**TOWER 2, LEVEL 23
DARLING PARK, 201 SUSSEX ST
SYDNEY NSW 2000**

MP 08_0241 MOD 6

We write in response to submissions received in regard to the Modification 6 application for Major Project 08_0241 at 100 Mount Street North Sydney. We have reviewed the submissions received in consultation with the proponents and provide the attached table of response on their behalf.

RESPONSE TO SUBMISSIONS MP 08_0241 MOD 6

Shadow Analysis - 21 March Sheet 01

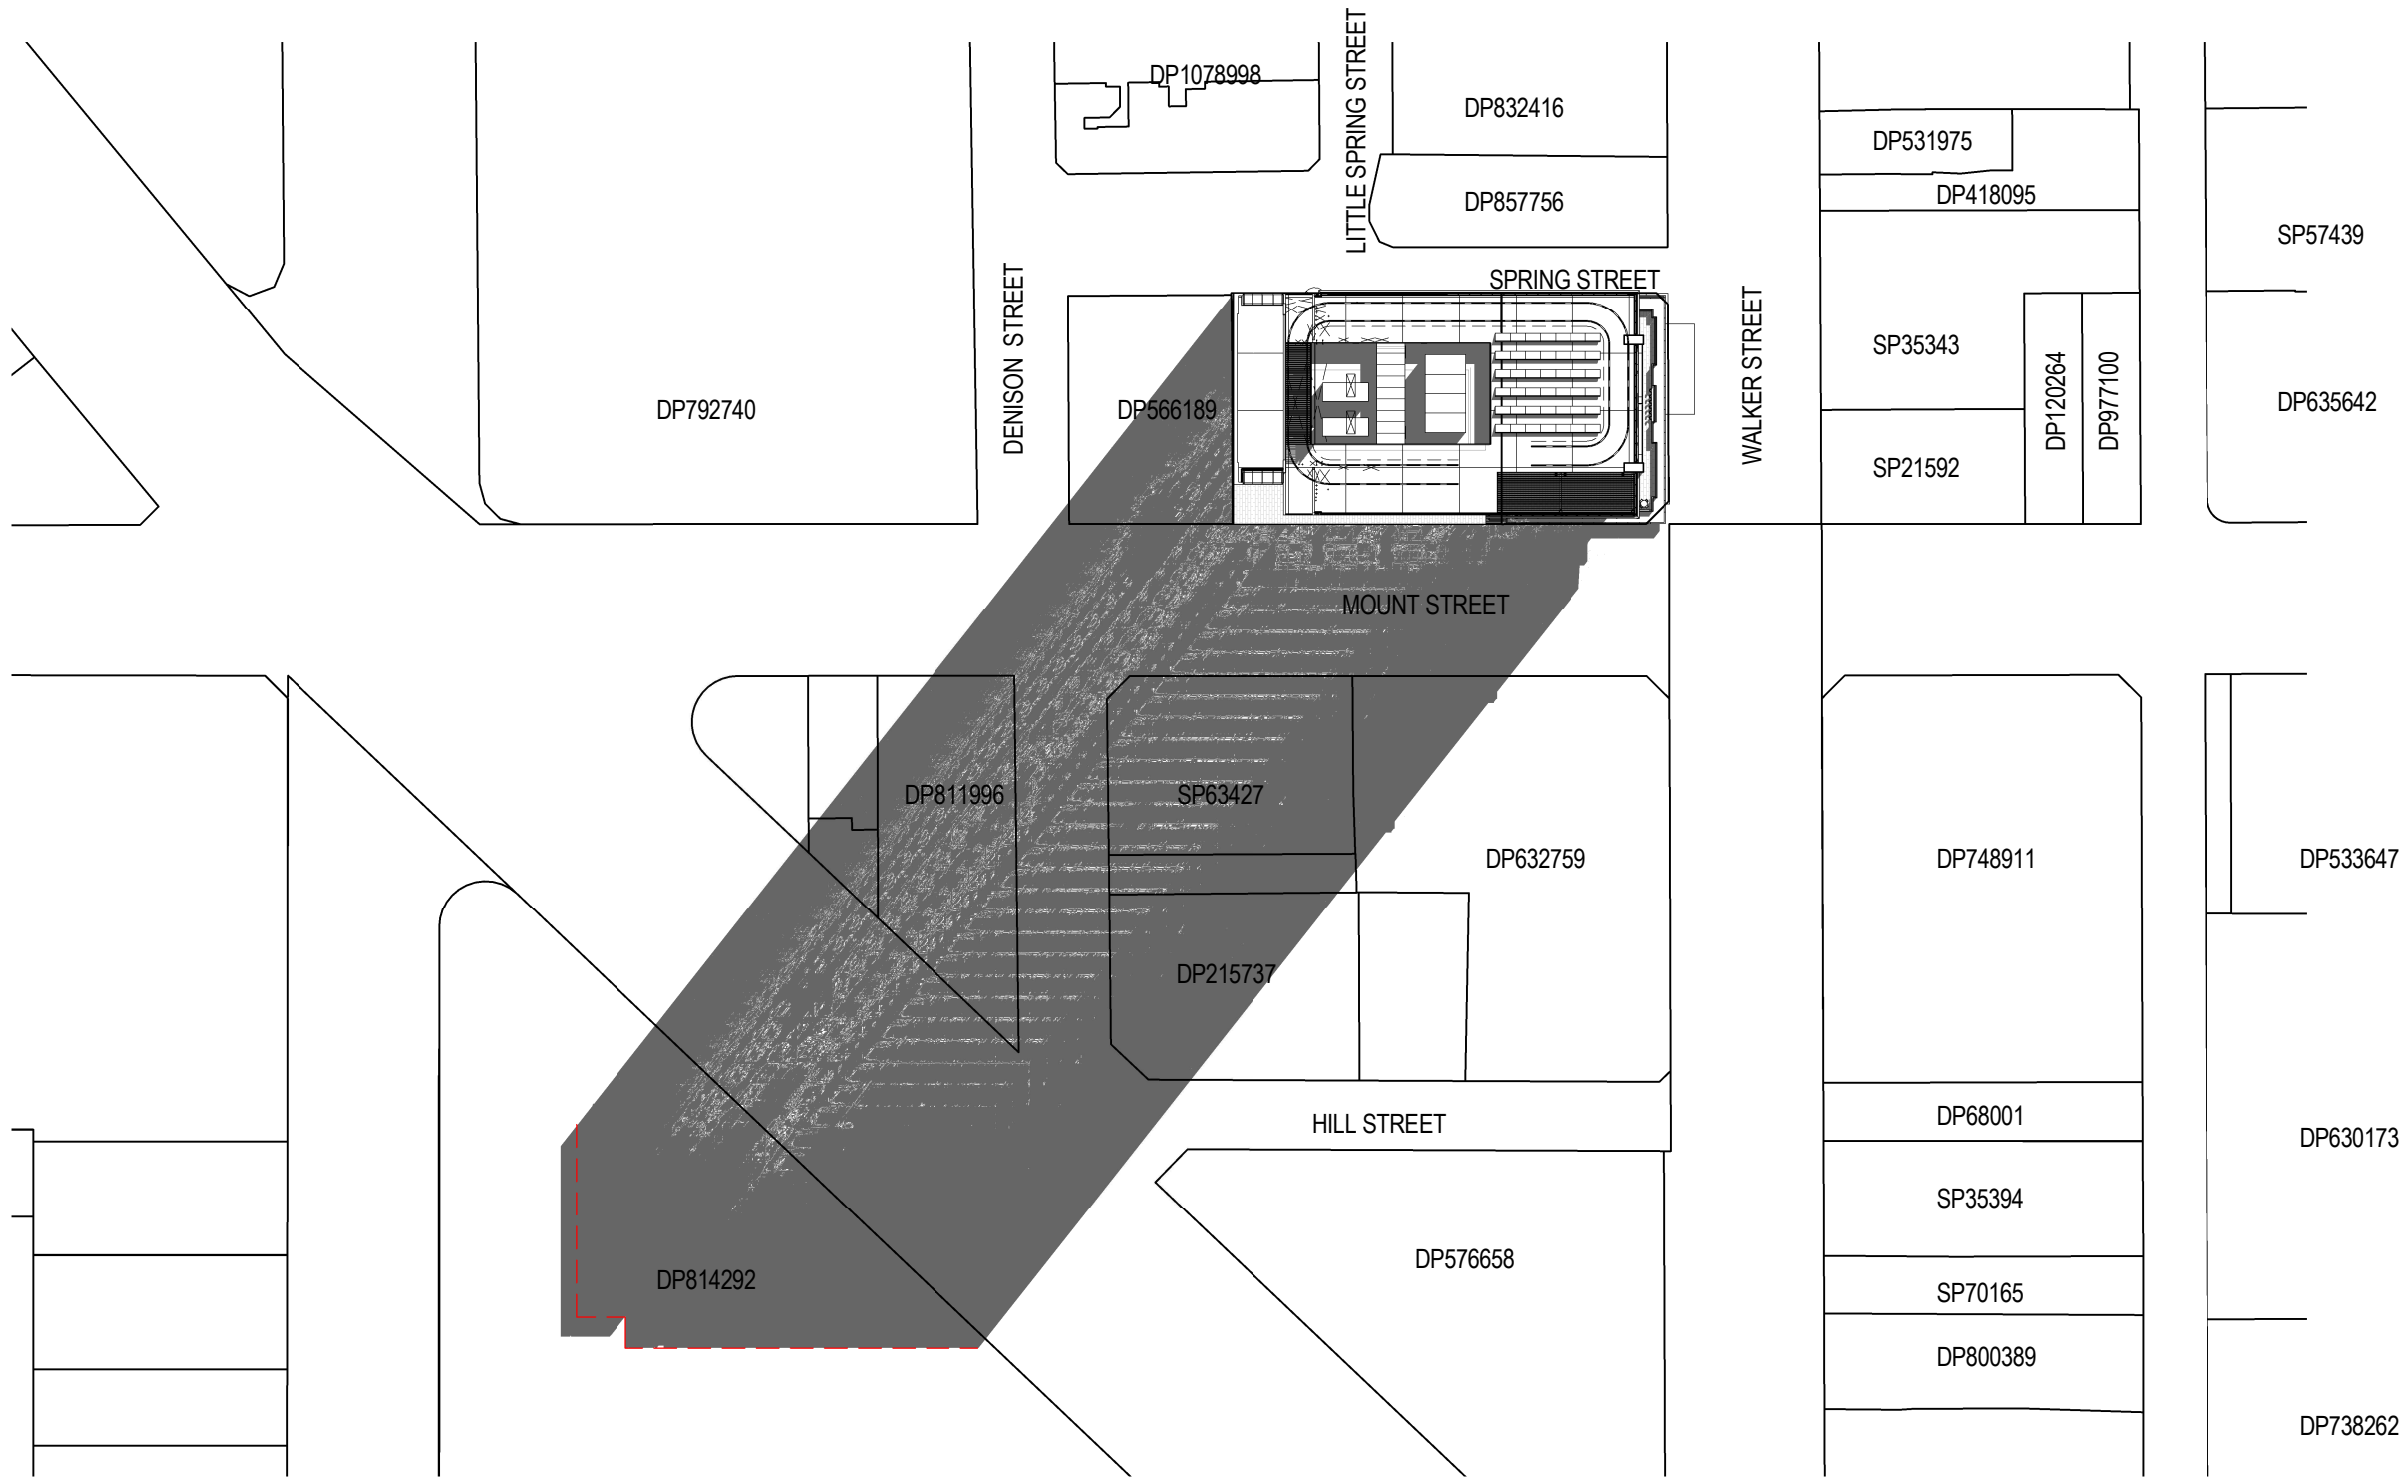
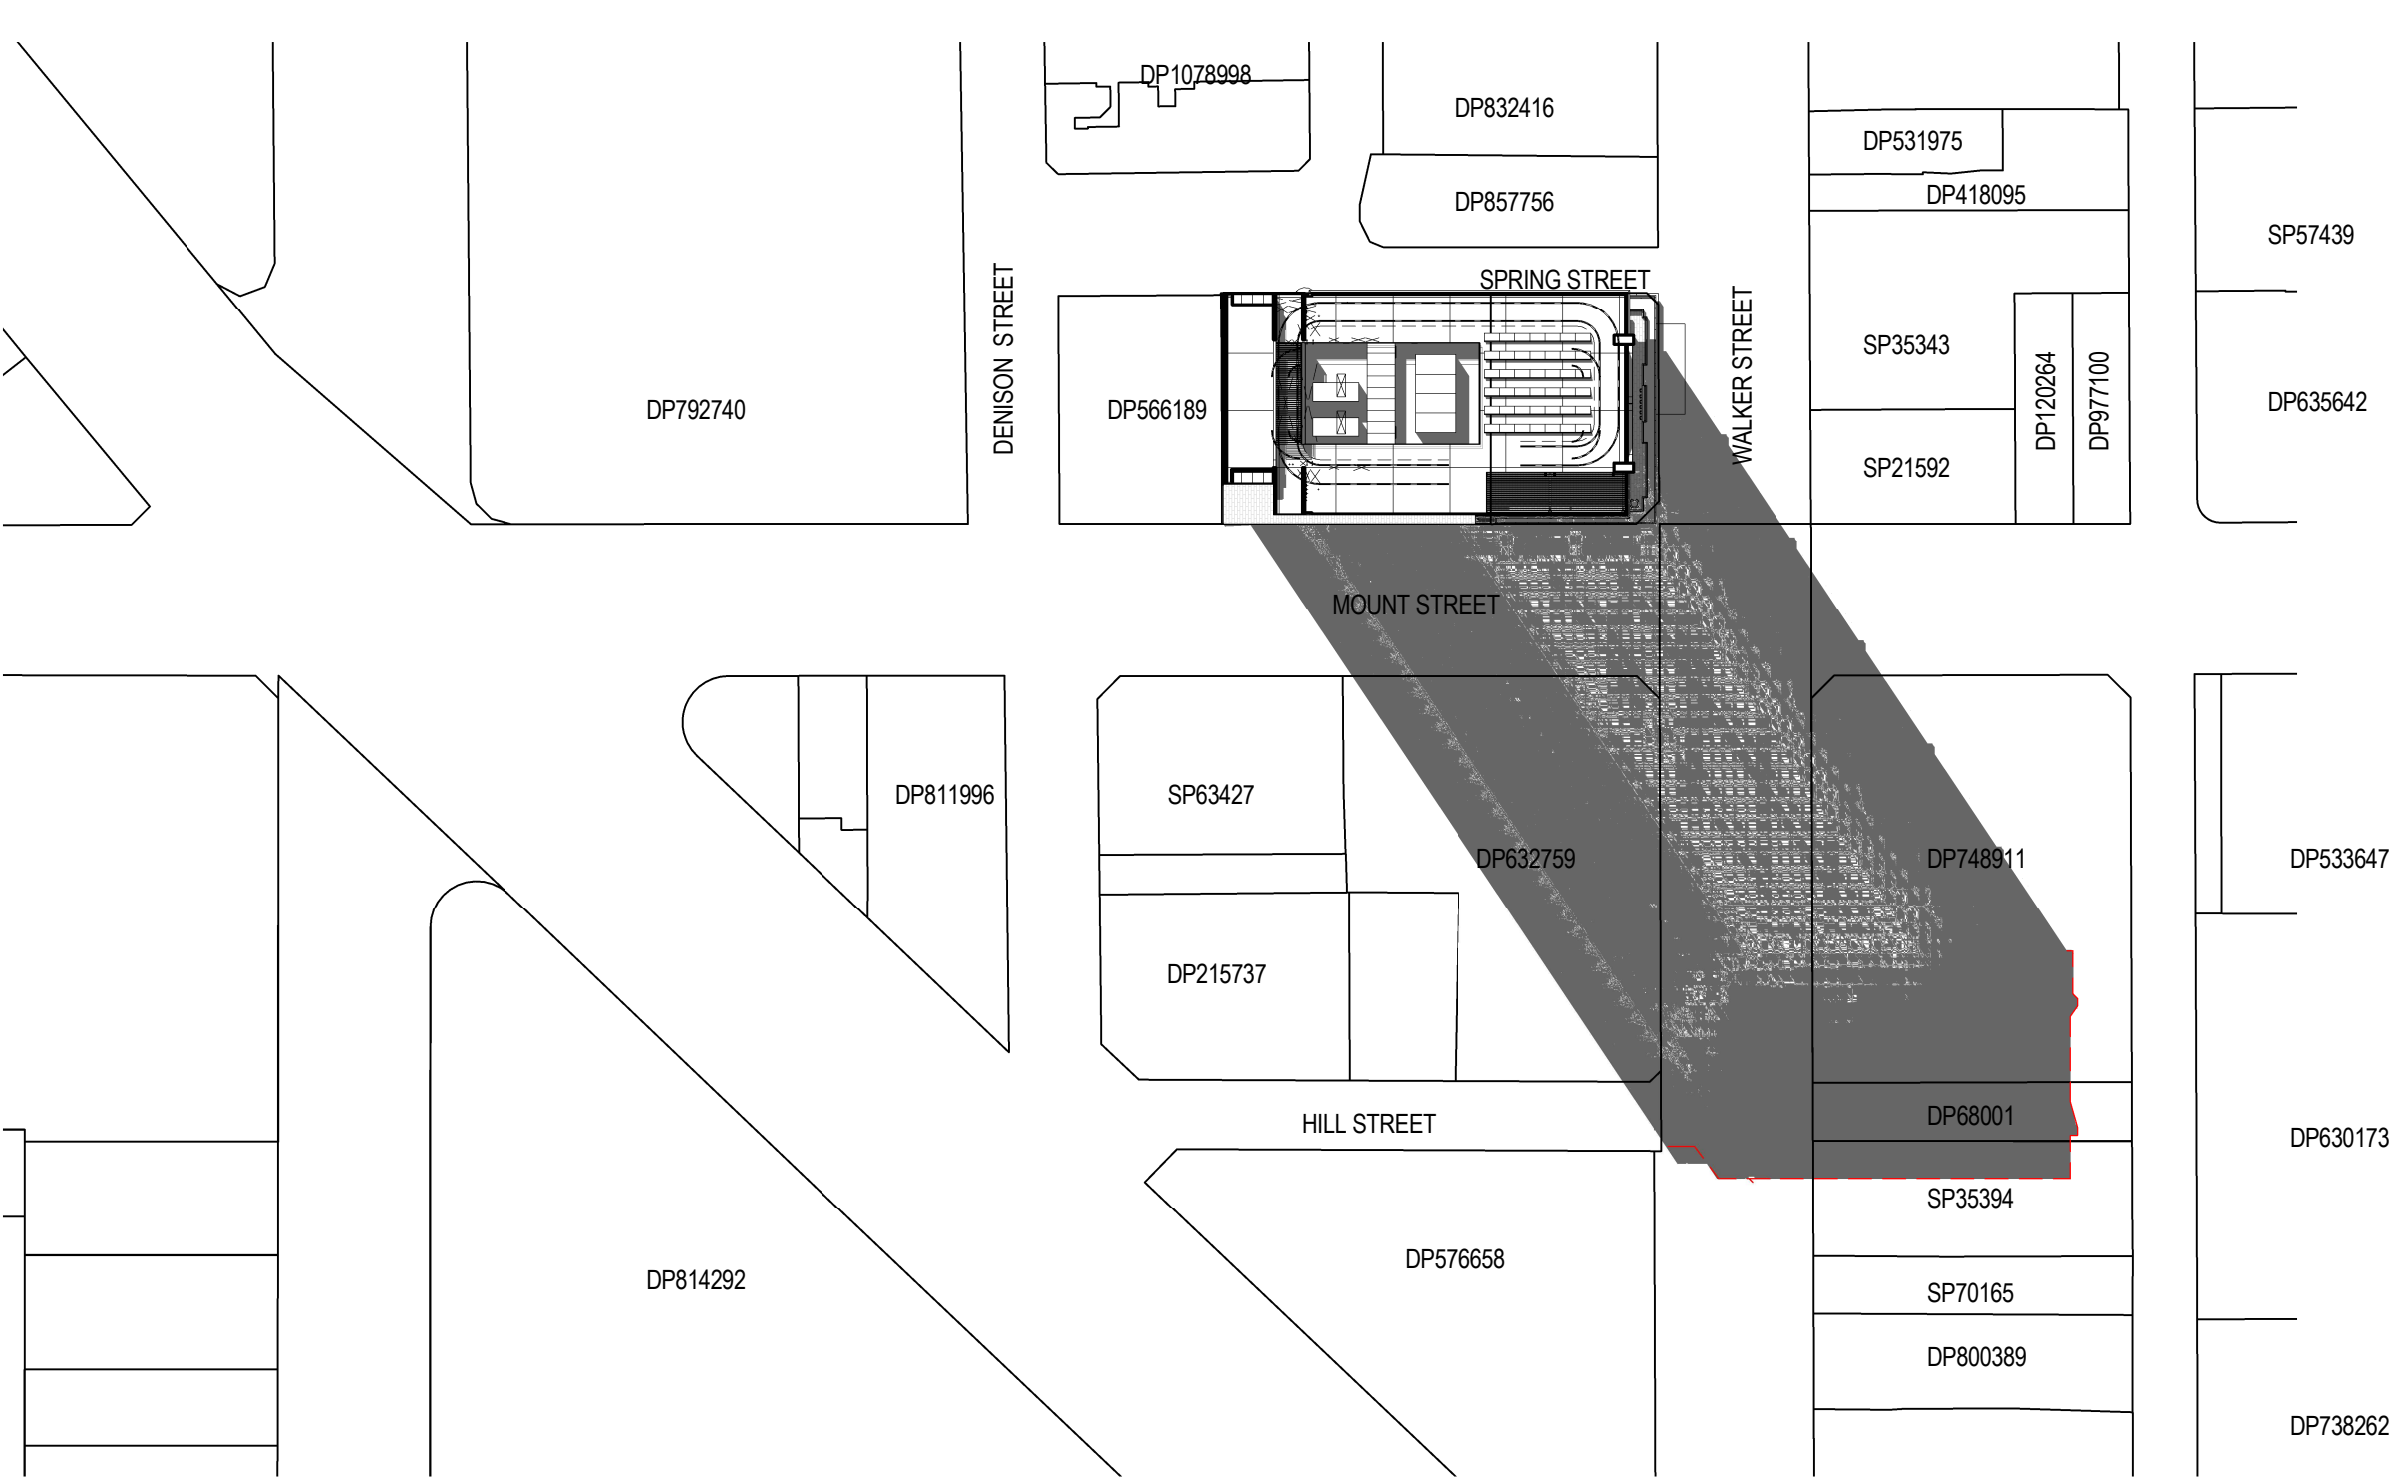
Submission	Issue/Comment	Response
	Views <i>The proposed development...is considered to significantly obstruct the views of the Beau Monde building.</i>	The proposed development which includes an additional 3.4m in height to accommodate the lift overrun and building maintenance facility will not significantly obstruct the views of the Beau Monde building. The existing bulk and scale of the building to the top of building façade remains unchanged at RL199.7.
	Solar Access <i>Although, it is acknowledged that the Beau Monde building, being located north of the development site, will not be the subject of overshadowing, this submission seeks also to articulate the wider public interest...the additional building height will further increase overshadowing with negative implications for many properties located to the south of the site.</i>	The proposal will not overshadow the Beau Monde building which is located north of the site. Shadow analysis diagrams provided with the application show that no new properties are impacted by the additional 3.4m in height. No adverse impact on solar access will result from the proposal.
